# ENG-SF18020-R1-FDR.pdf Markup Summary

DSD Proj  
**SF-1820**

# Grading Eros Plan V\_1.pdf Markup Summary

**HISTORIC CONDITION**

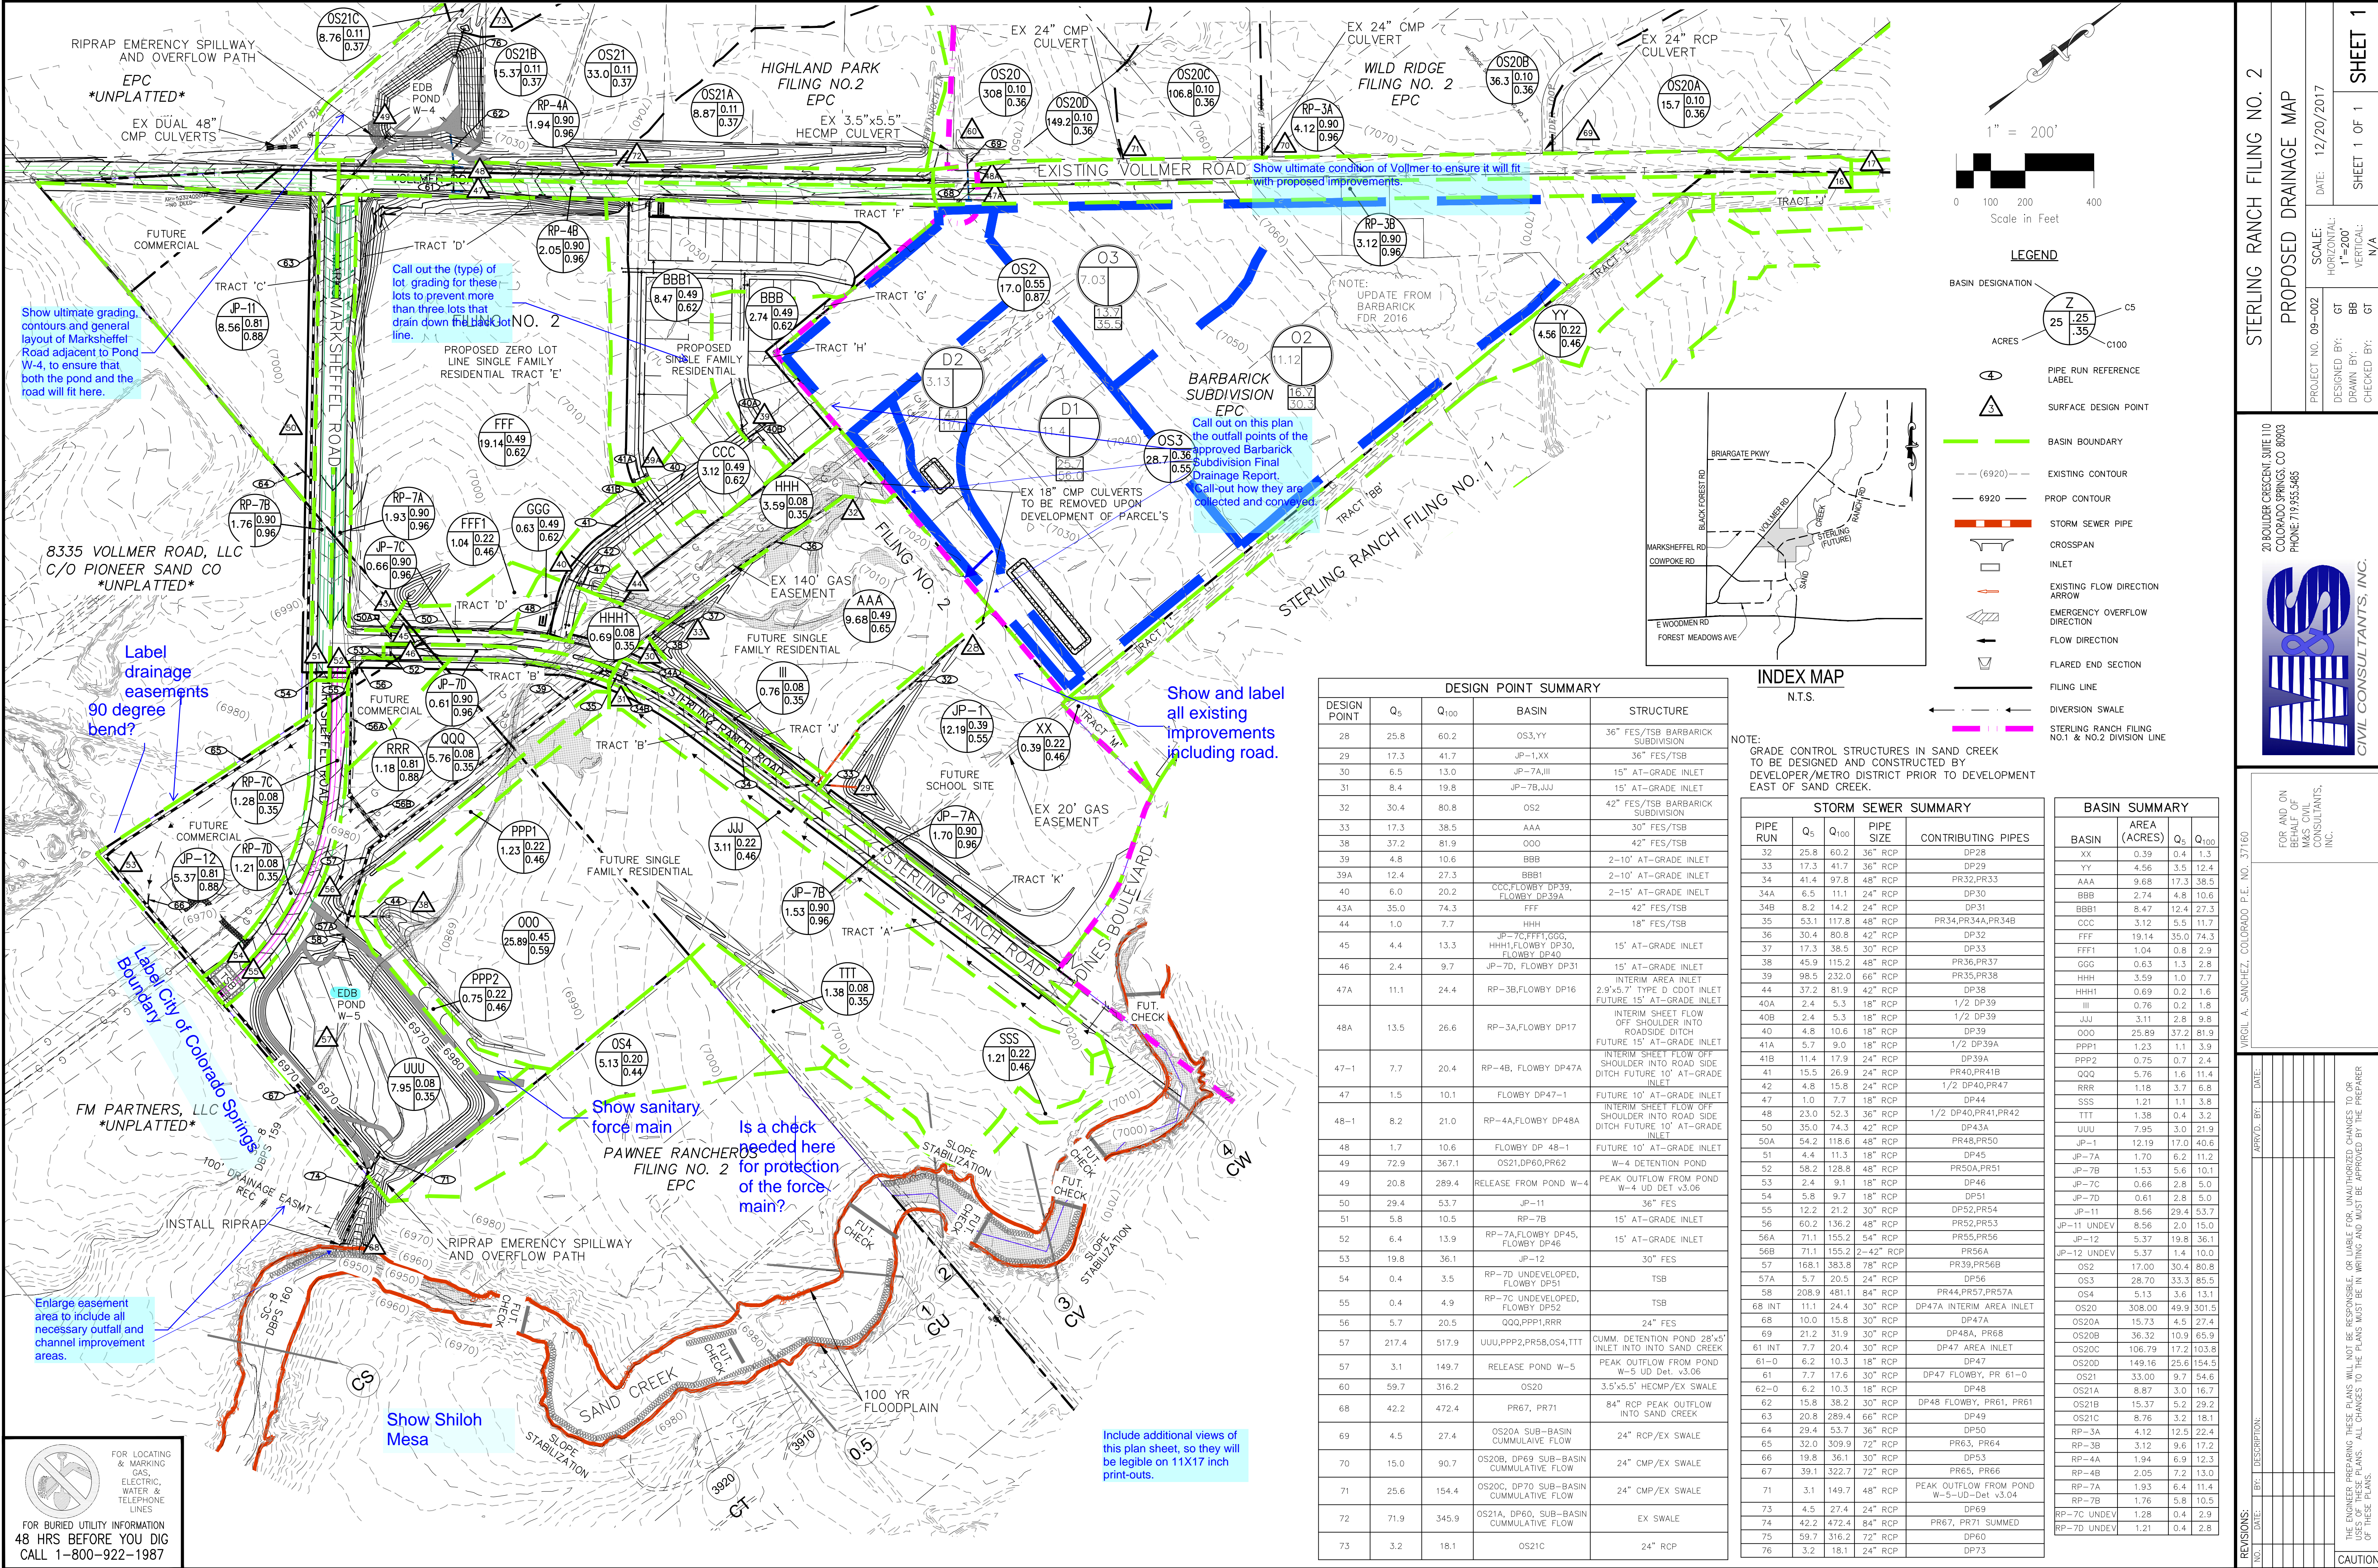
Please provide an additional existing condition drainage map at the same scale as the proposed condition map. This exhibit should show the show the boundary for this site.

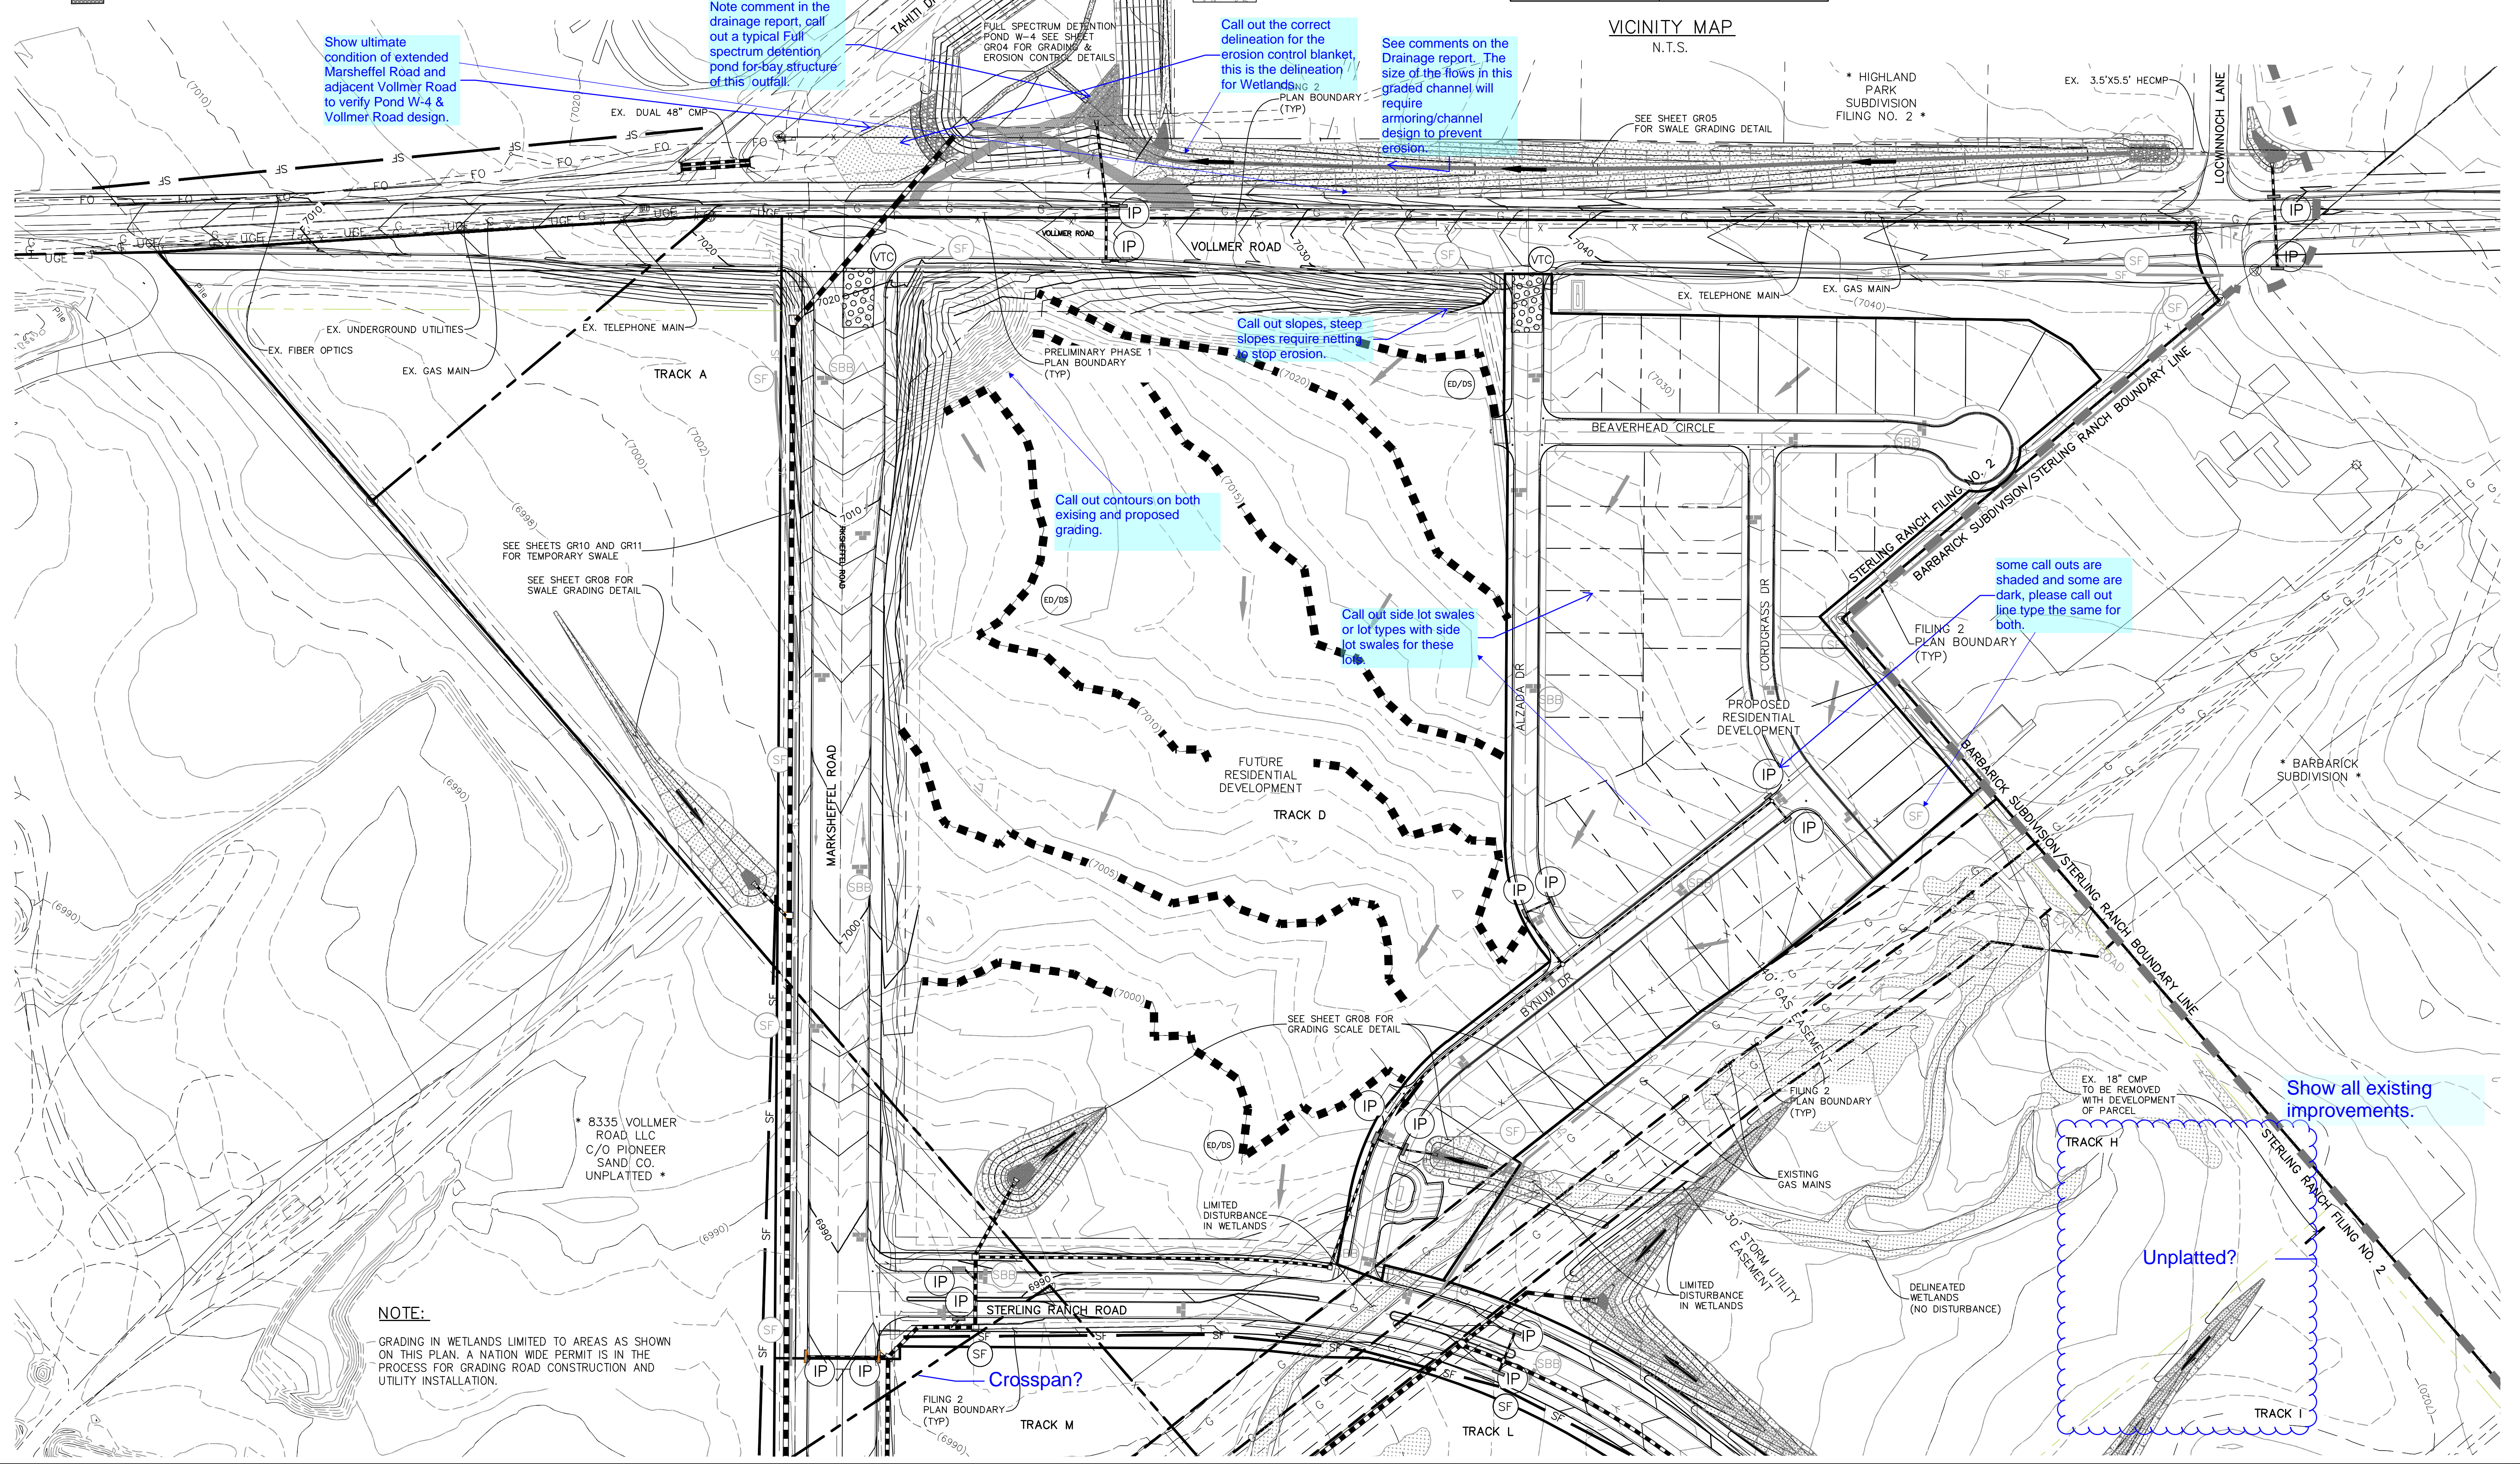
Show ultimate condition of extended Marsheffel Road and adjacent Vollmer Road to verify Pond W-4 & Vollmer Road design.

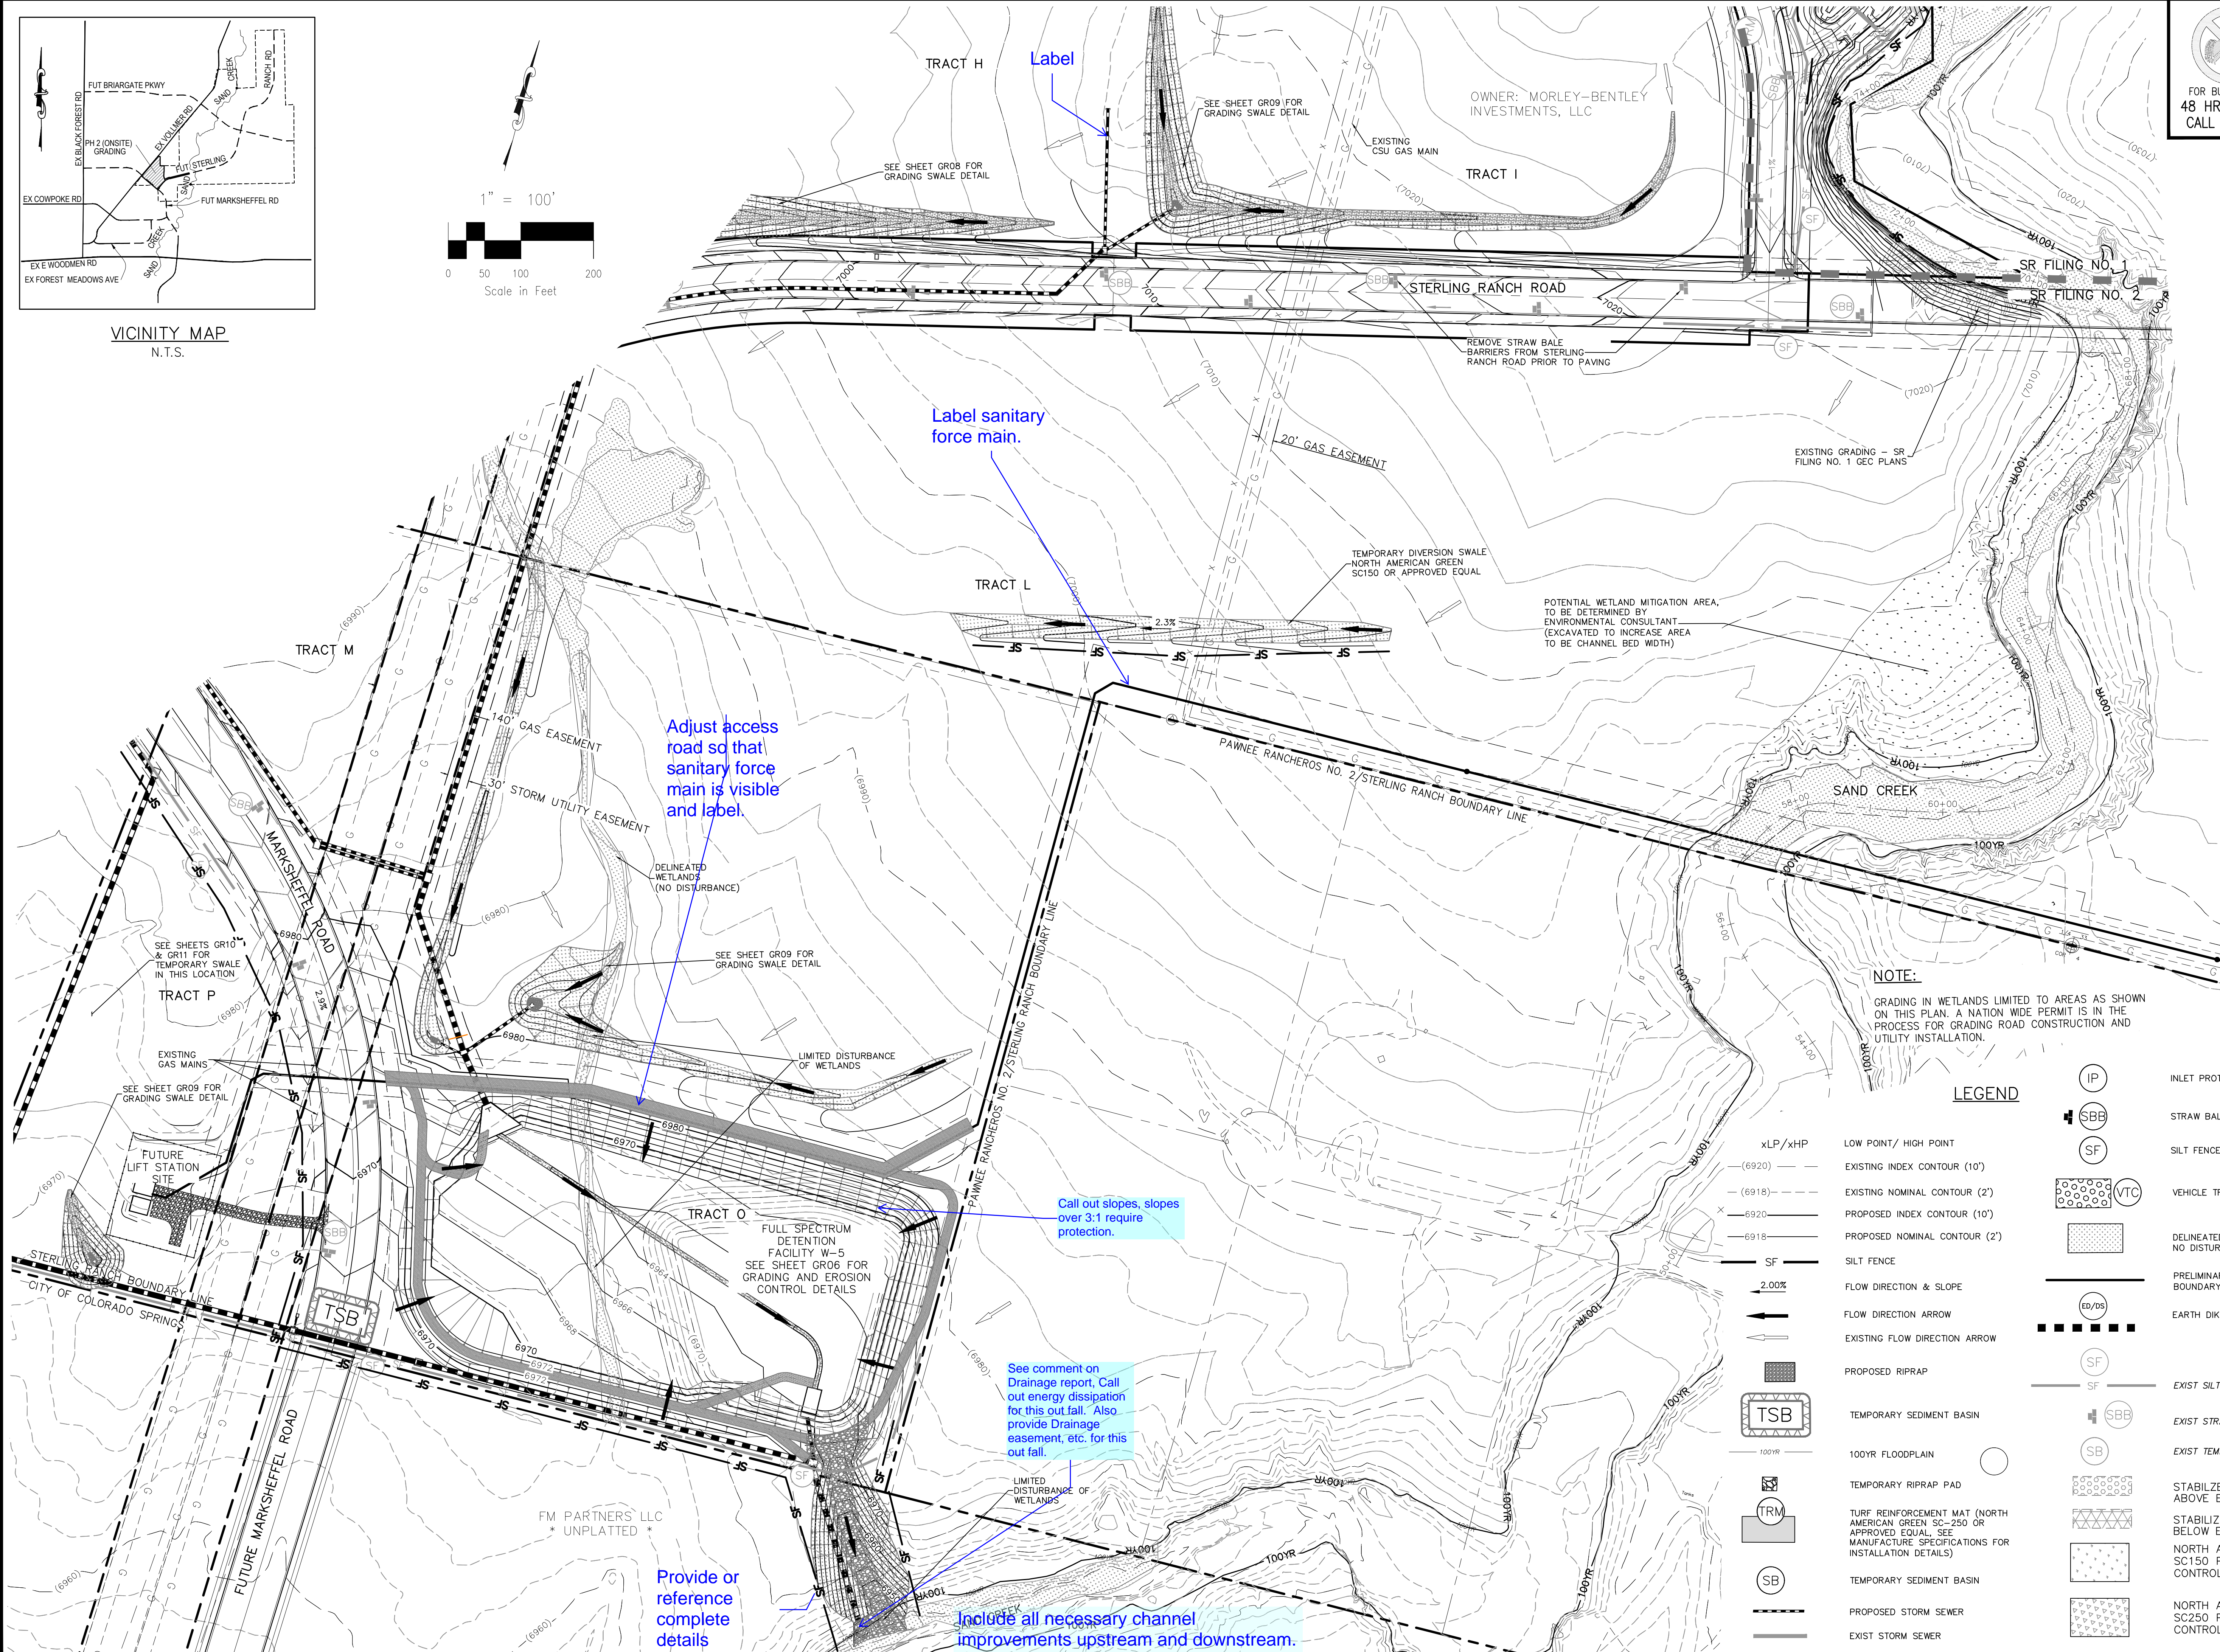
Show sanitary force main
